COLORADO GEOLOGICAL SURVEY

August 29, 2018

Subject: Sterling Ranch Filing No. 2, Final Plat, File No. SF1820
El Paso County, CO; CGS Unique No. EP-19-0014

The Colorado Geological Survey (CGS) has reviewed the Final Plat submittal for Sterling Ranch Filing No. 2. We understand from the letter of intent that the Final Plat includes 49 single-family lots, 1 tract for future residential lots, 10 tracts for landscaping, public improvements and public utilities, the widening of Vollmer Road adjacent to the filing, and the construction of Marksheffel and Sterling Ranch Road within the filing. CGS previously reviewed the Sterling Ranch Sketch Plan in our letter dated December 19, 2007.

A PORTION OF THE E 1/2 SE 1/4 OF SECTION 32 AND THE S 1/2 SW 1/4 OF SECTION 33, TOWNSHIP 12 SOUTH, RANGE 65 WEST, AND THE NW 1/4 OF NW 1/4 OF SECTION 4 AND THE NE 1/4 OF NE 1/4 OF SECTION 5, TOWNSHIP 13 SOUTH, RANGE 65 WEST, BOTH OF THE 6TH PRINCIPAL MERIDIAN, EL PASO COUNTY, STATE OF COLORADO

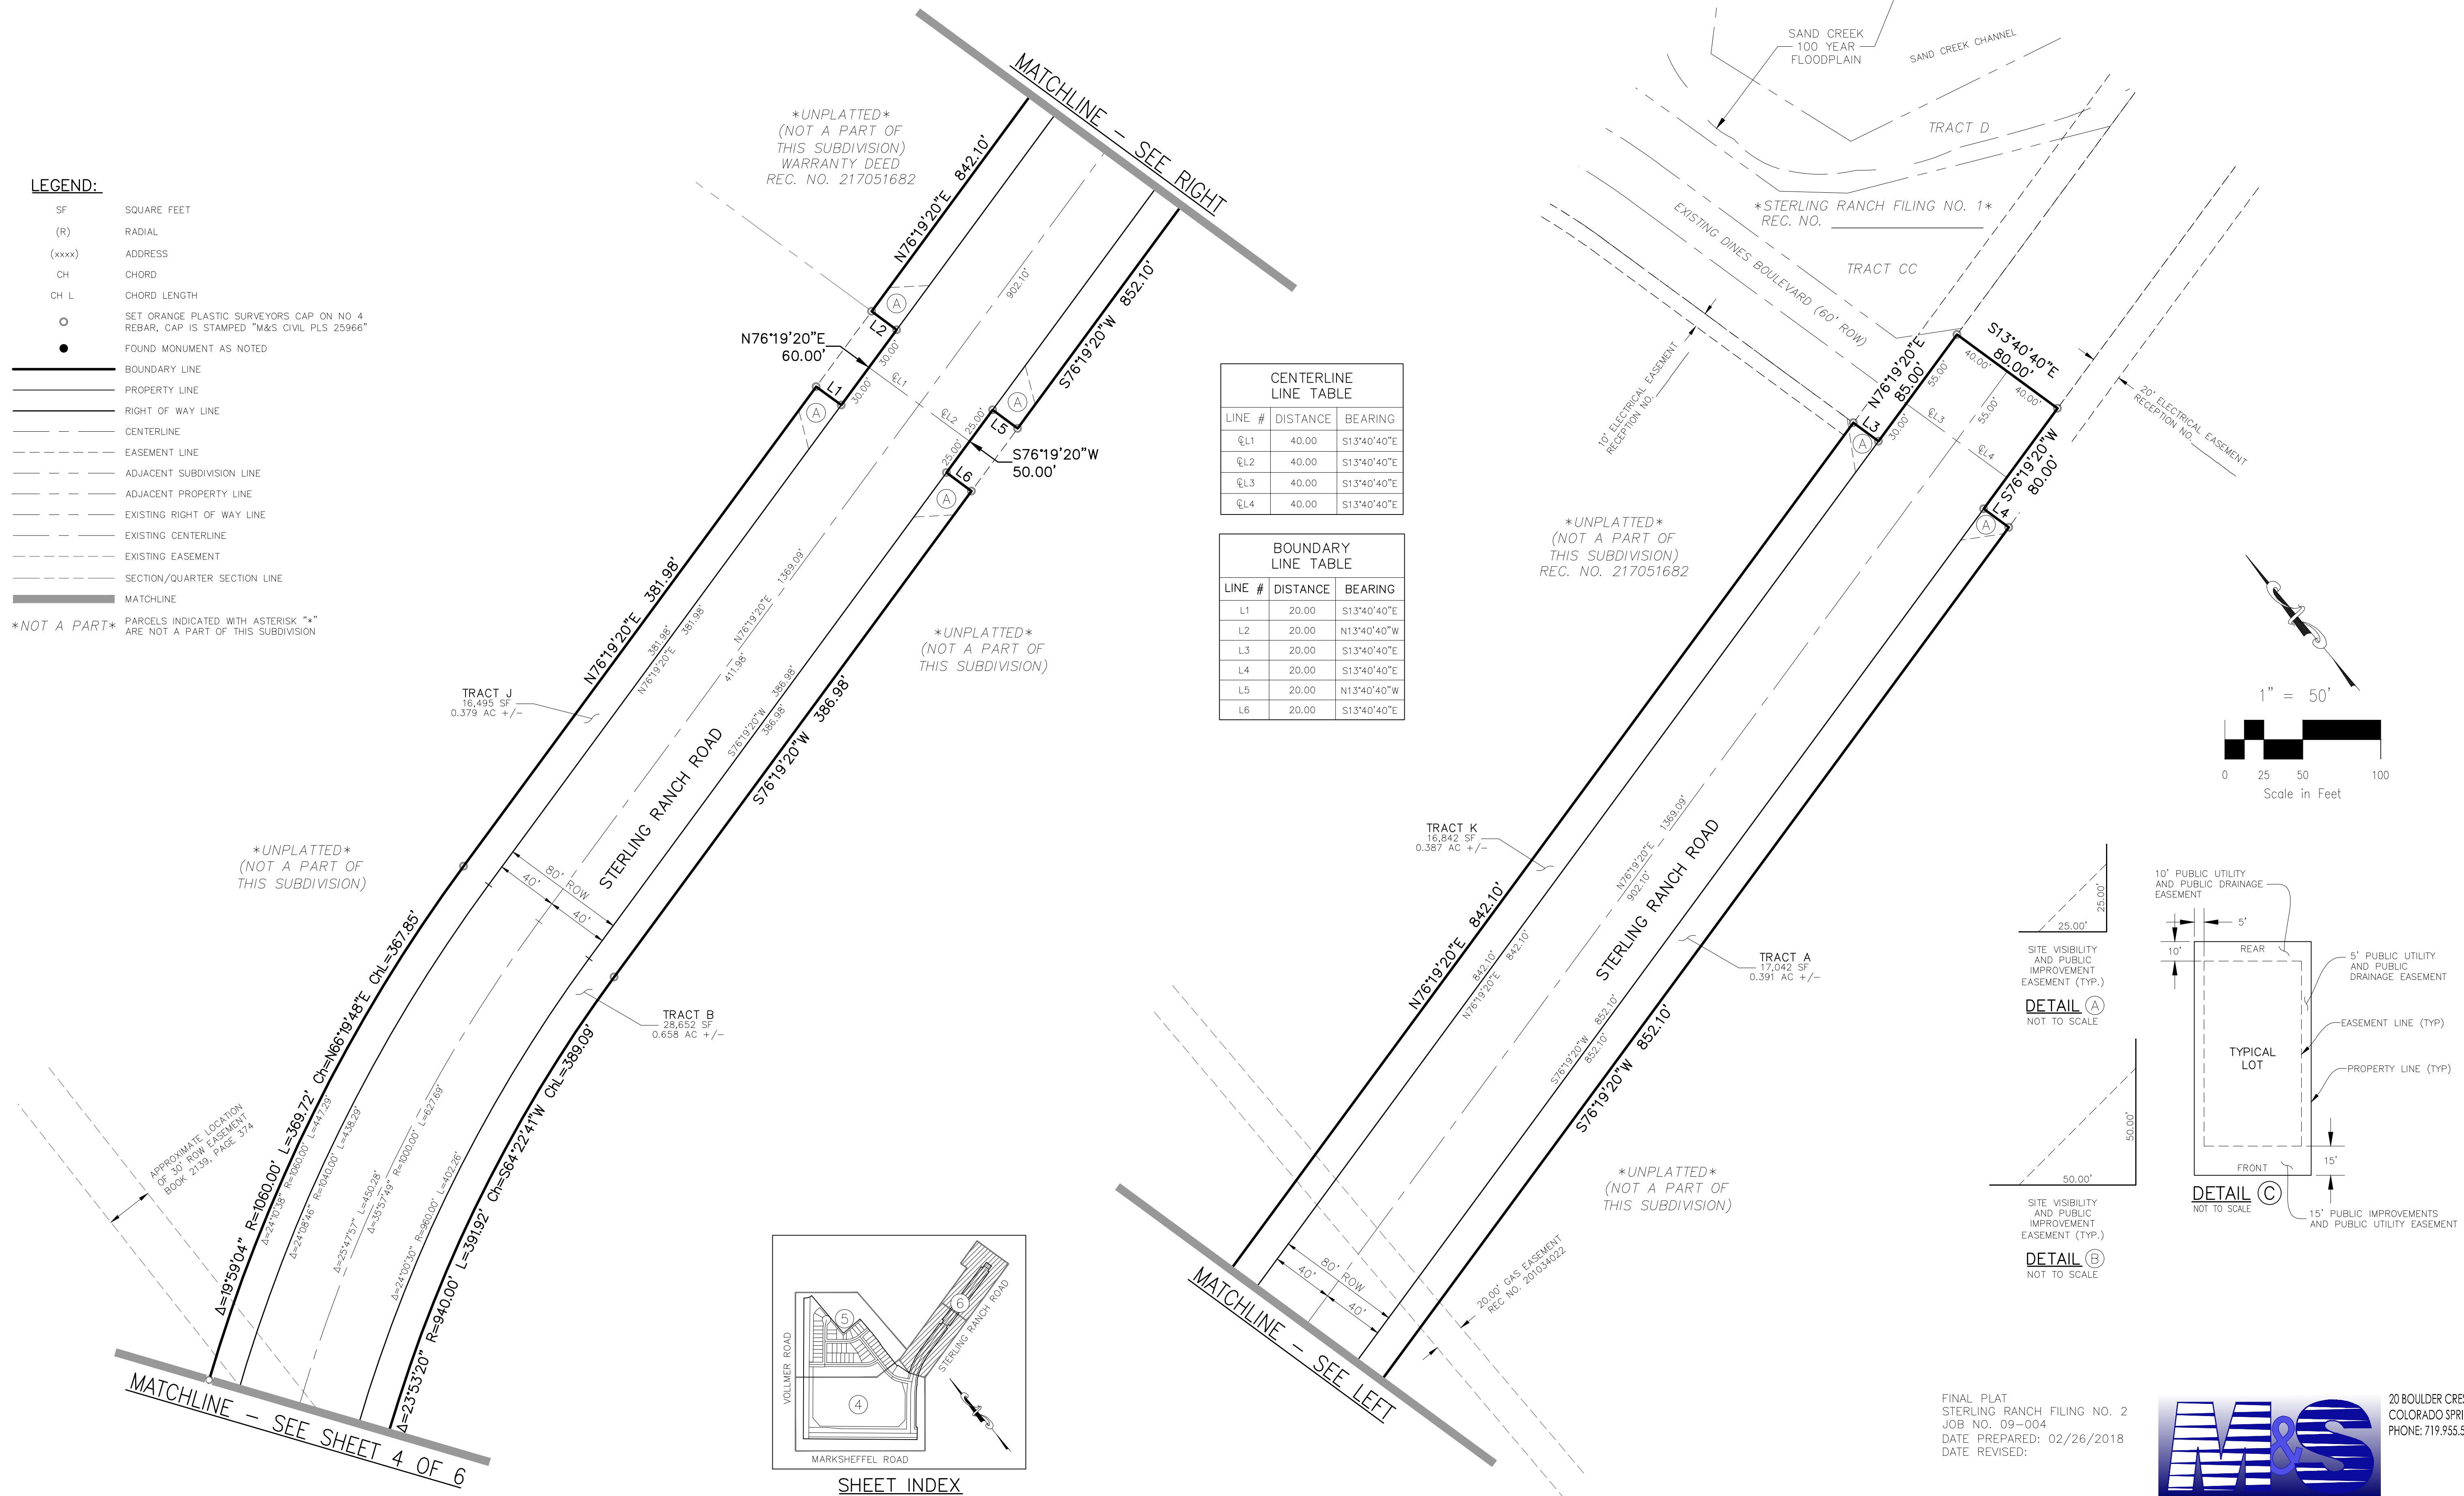
Geologic Hazard Report and Final Plat: Entech's report(s) identify areas of geologic hazards and provides preliminary conceptual plans for mitigation of these hazards. An unnumbered plat note between notes 25 and 26 states: "*The following lots and tracts have been found to be impacted by geologic hazards. Mitigation measures and a map of the hazard area can be found in the report (Entech, 2009) ...The following lots and tracts are impacted: Unstable slopes: Lots 21 through 30 Shallow groundwater: Tracts C, D and E Seasonal shallow groundwater: Tracts B, D, I, and J*". The copies of the geotechnical reports we received do not include all the figures. Figure 5 and 8 are missing from the 2009 report. Figure 5 (2009 report) is the Development Plan/Test Boring Location Plan and Figure 8 (2009 report) is the Geology Map/Engineering Geology map. We are unable to verify that the areas identified with geologic hazards by Entech are the same areas discussed in the plat notes. We would appreciate the opportunity to review these figures compiled by Entech.

We recommend that the geotechnical engineer provide engineering recommendations based on the Final Plat,

Grading and Drainage Plans for at least the following issues:

- the location of preliminary building setback lines in unstable and potentially unstable slope areas, and/or comments on planned site grading and if it will mitigate these (and other) hazards, and
- feasibility of basements in areas of seasonal and permanent shallow groundwater

These geotechnical recommendations should evaluate both the proposed lots and tracts and be included in the plat notes.

These plans reference a soils report by CTL Thompson. If a report has been prepared by CTL Thompson we recommend that it be submitted for review or the reference be changed to the report of record (i.e. Entech). The grading plan states in note 27 that a portion of the property "*is located within a designated FEMA floodplain...*" We can find no indication of this on the plat.
